**RE: Fontaine Boulevard and East Fork Jimmy Camp Creek at Lorson Ranch,  
Final Design. El Paso County, Colorado (Kiowa Project No. 16031)**

**CDR-16-009 Lorson Ranch East, East Fork Jimmy Camp Creek Drainageway  
and Fontaine Boulevard Bridge Design- Review 5**

**LORSON RANCH**  
**FONTAINE BOULEVARD BRIDGE AND CHANNEL DESIGN**  
**GRADING PLAN & EROSION CONTROL PLAN**  
EL PASO COUNTY, COLORADO

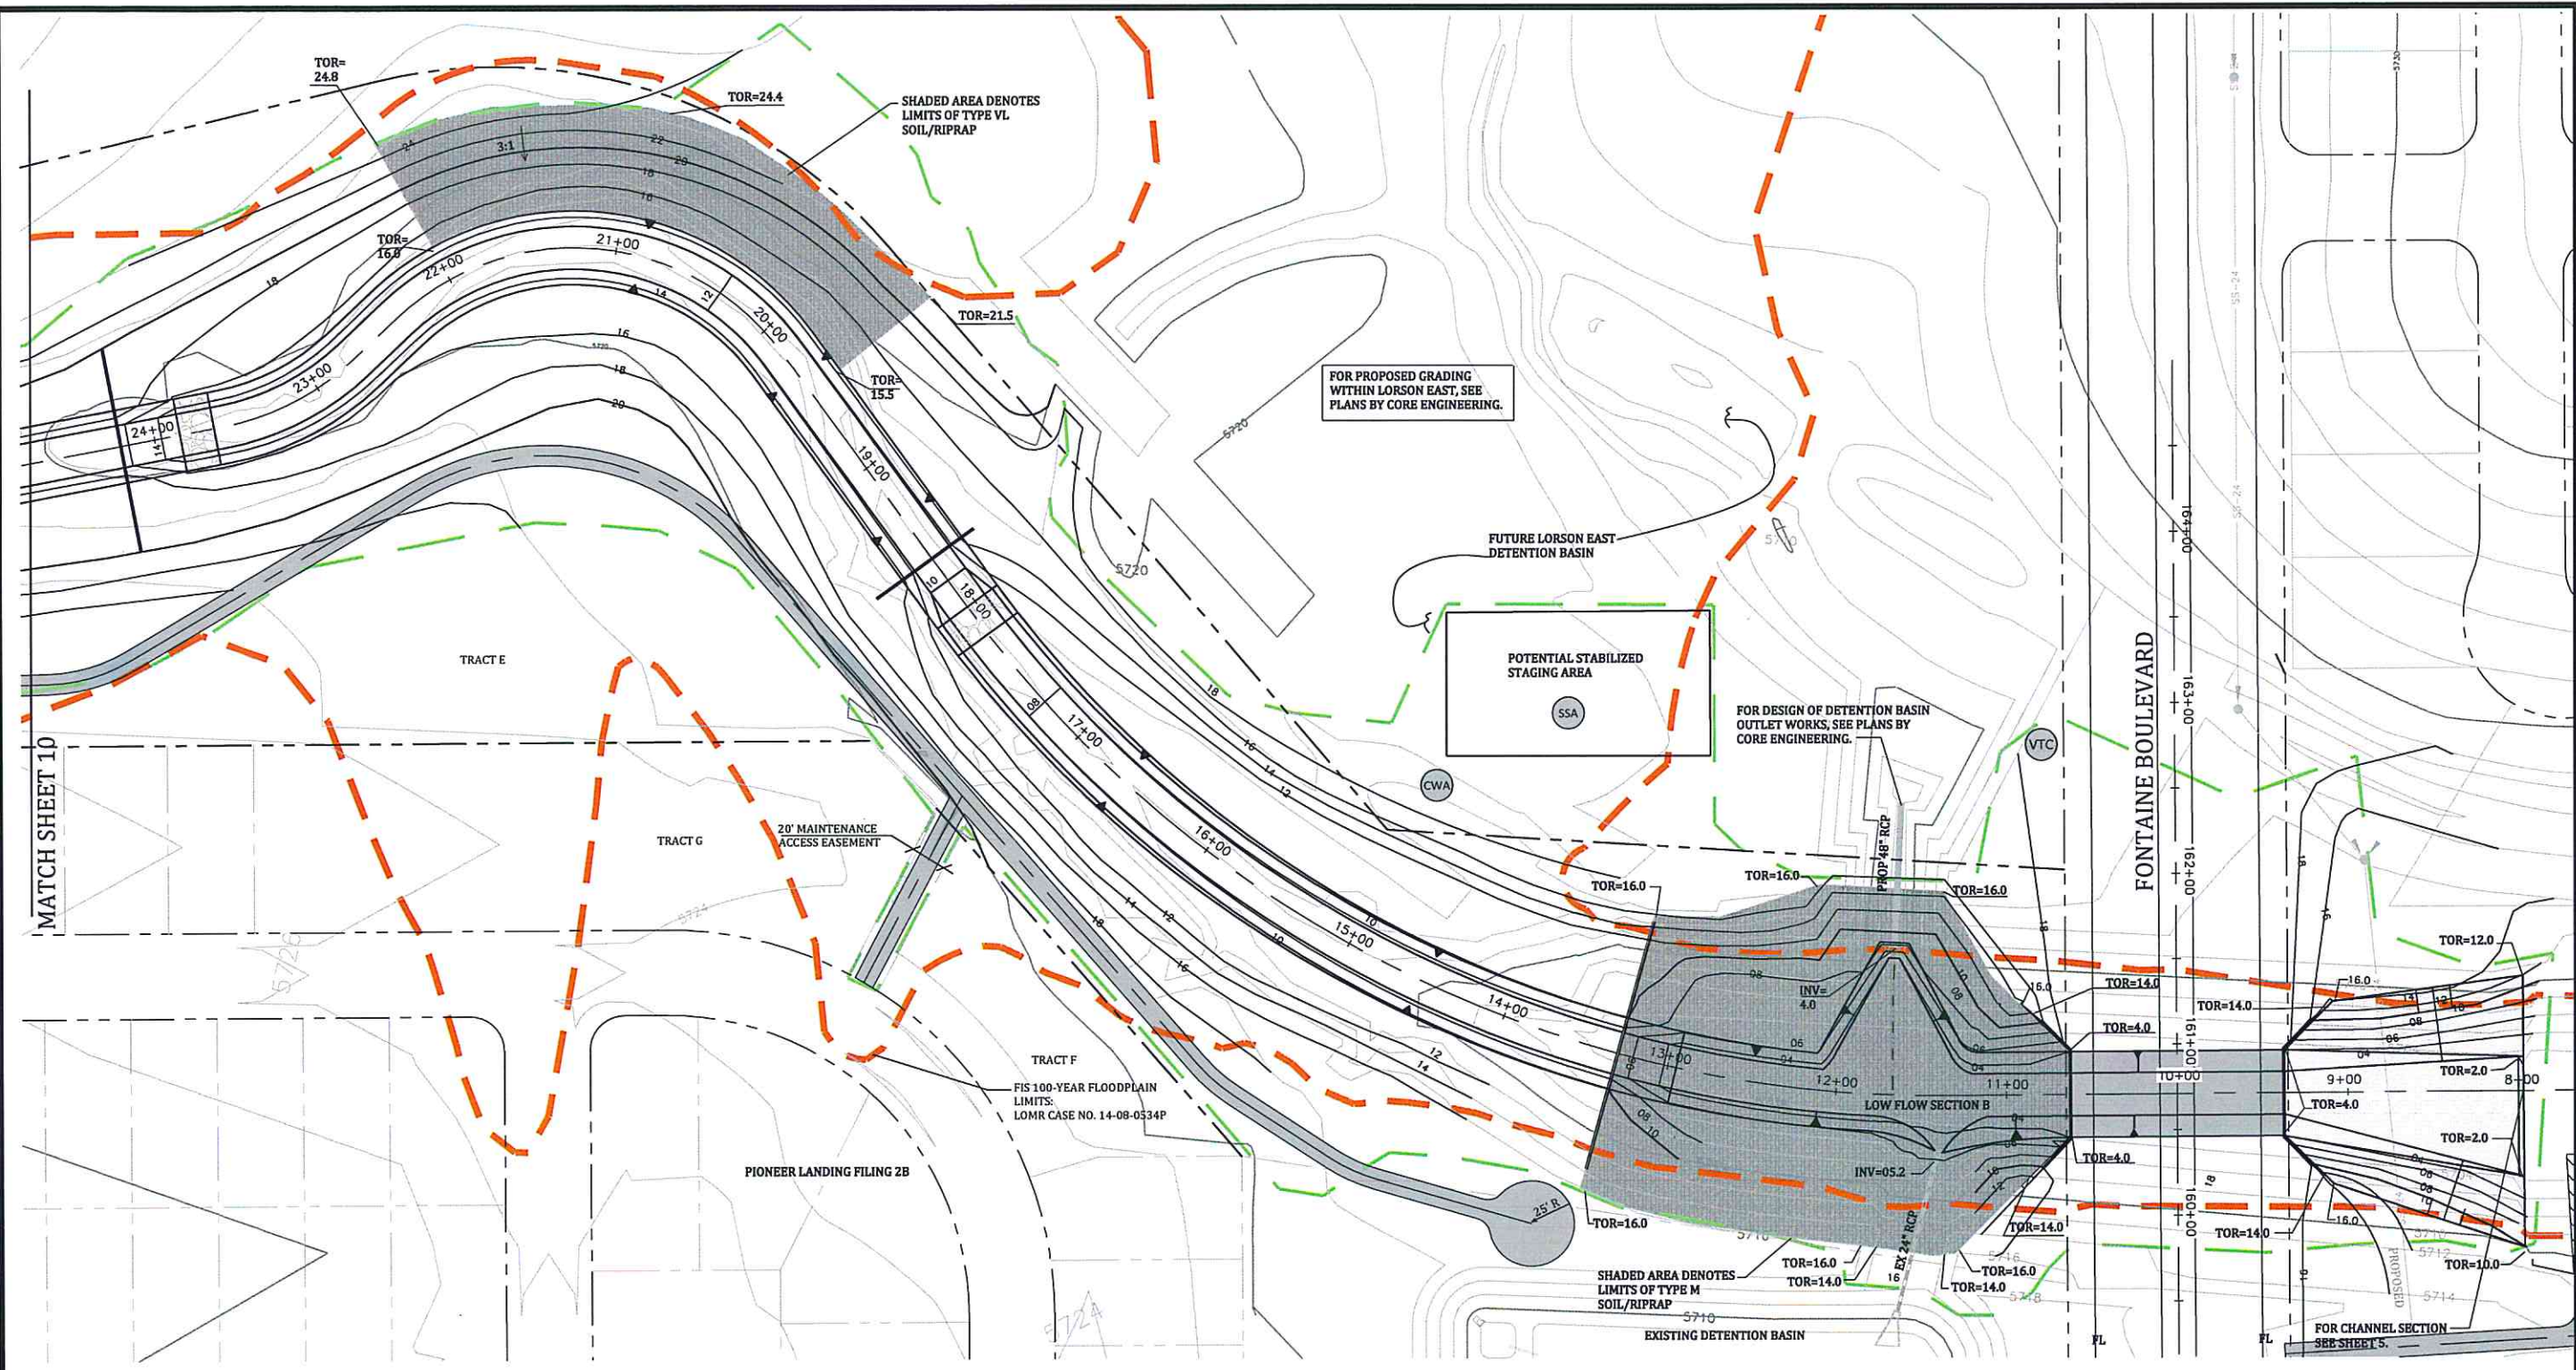
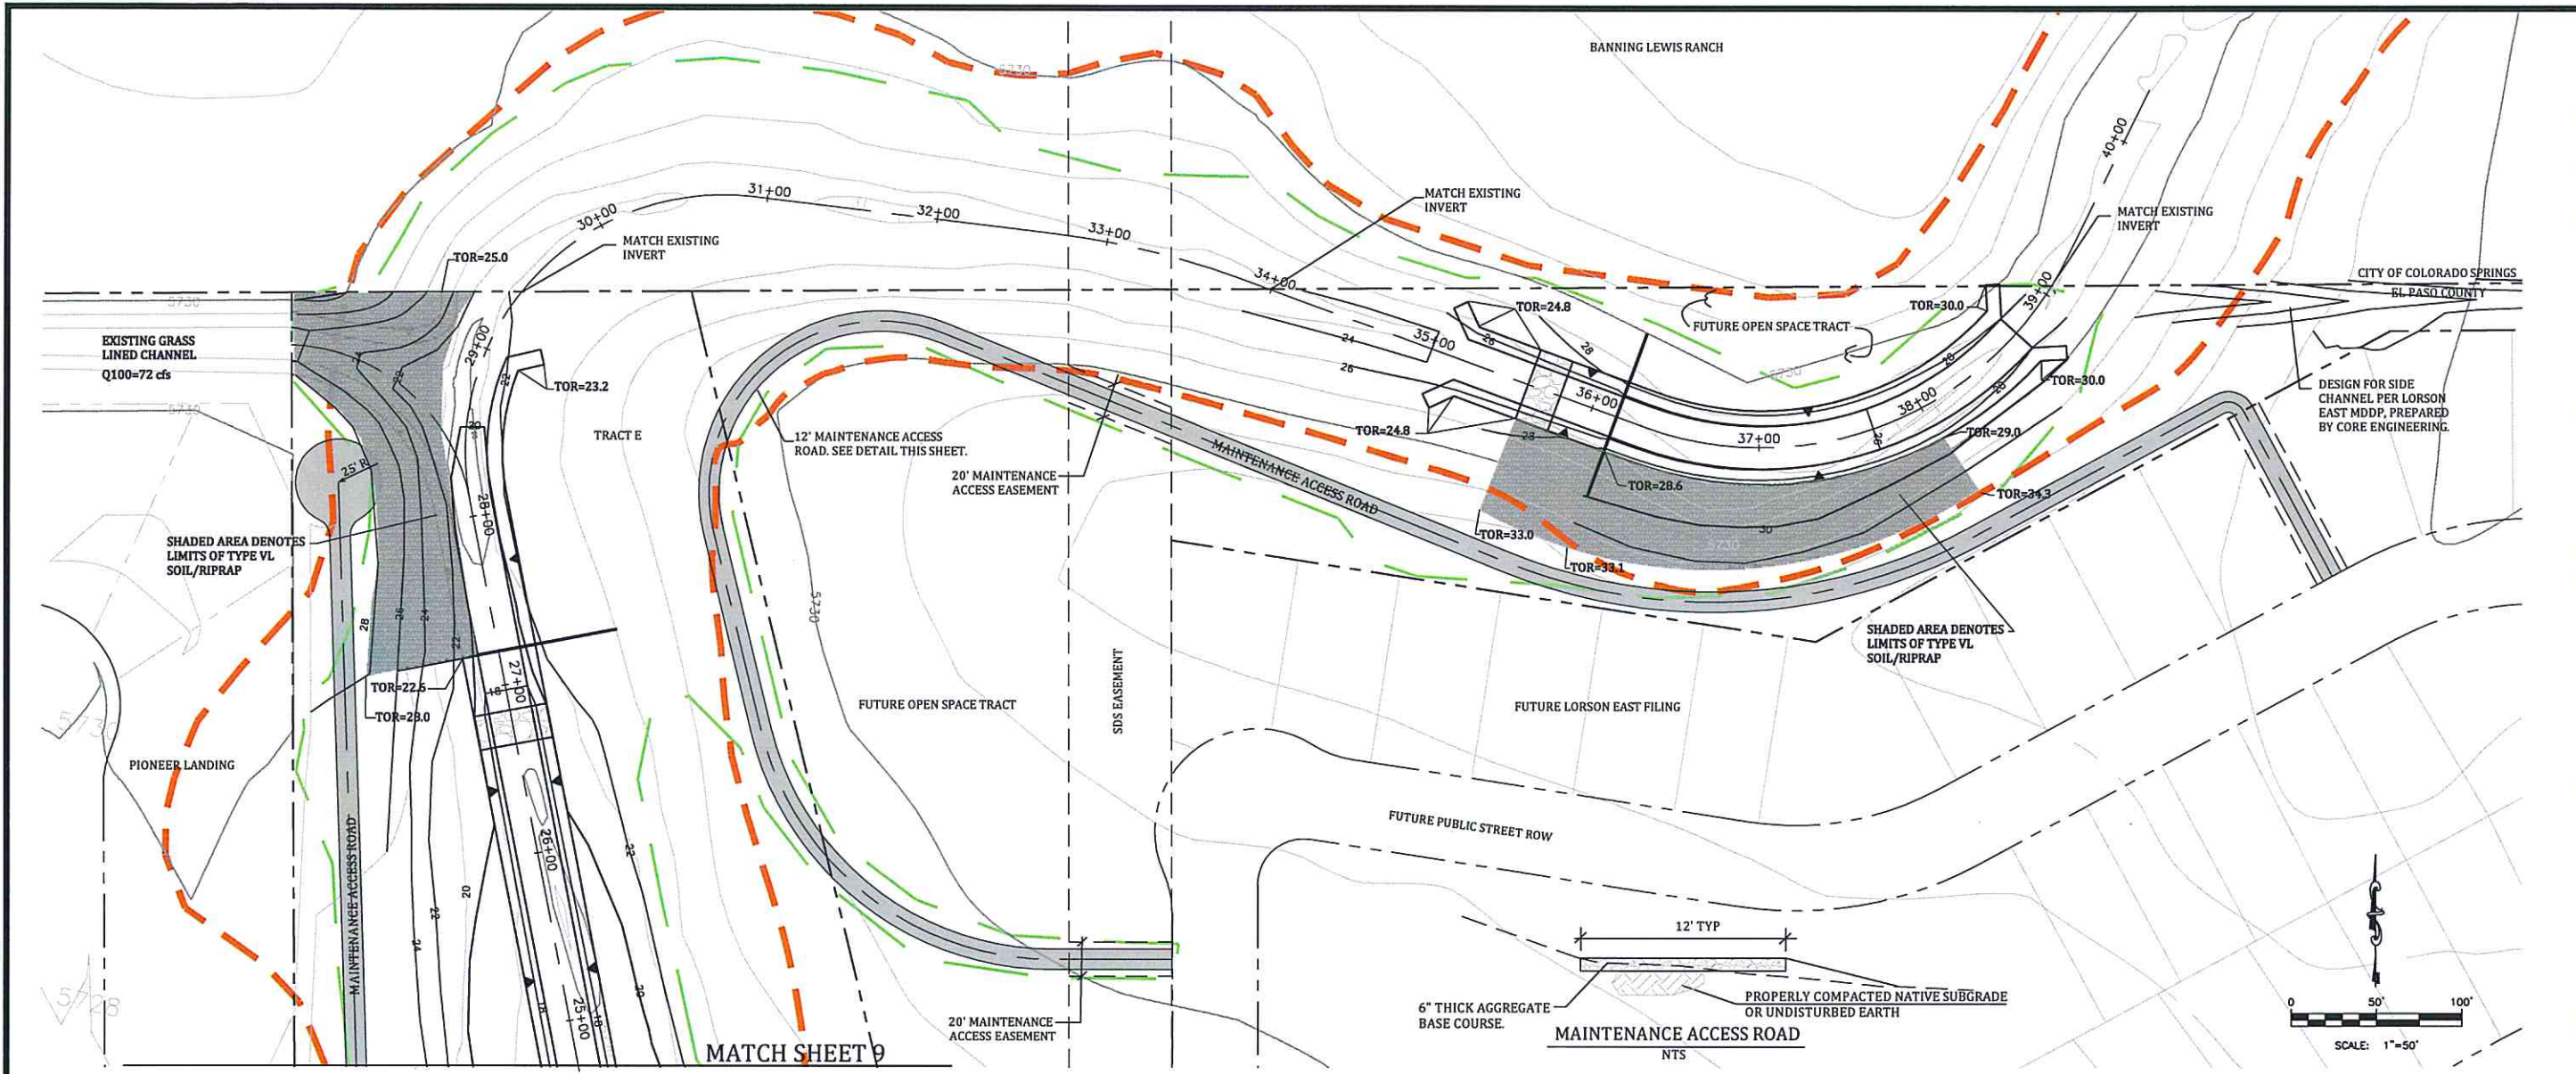
1. Partially Resolved: Design plans still need to be revised to reflect a stabilized access to the downstream side of the Fontaine Boulevard bridge per the County's latest round of comments.
2. Resolved through latest round of comments.
3.
  - a. Resolved.
  - b. In progress.
  - c. Resolved: there is no offsite grading anticipated in this project.
4. Resolved through latest round of comments.
5. Comment noted. There will be no work within the property north of Lorson Ranch as part of this project. Coordination with the City of Colorado Springs Water Resource Engineering to confirm that the City would not require the channel work to extend into and through the Banning-Lewis Ranch property. Documentation of this coordination and confirmation with the City has been provided to PCD via e-mail correspondence between El Paso County PCD and the City of Colorado Springs.
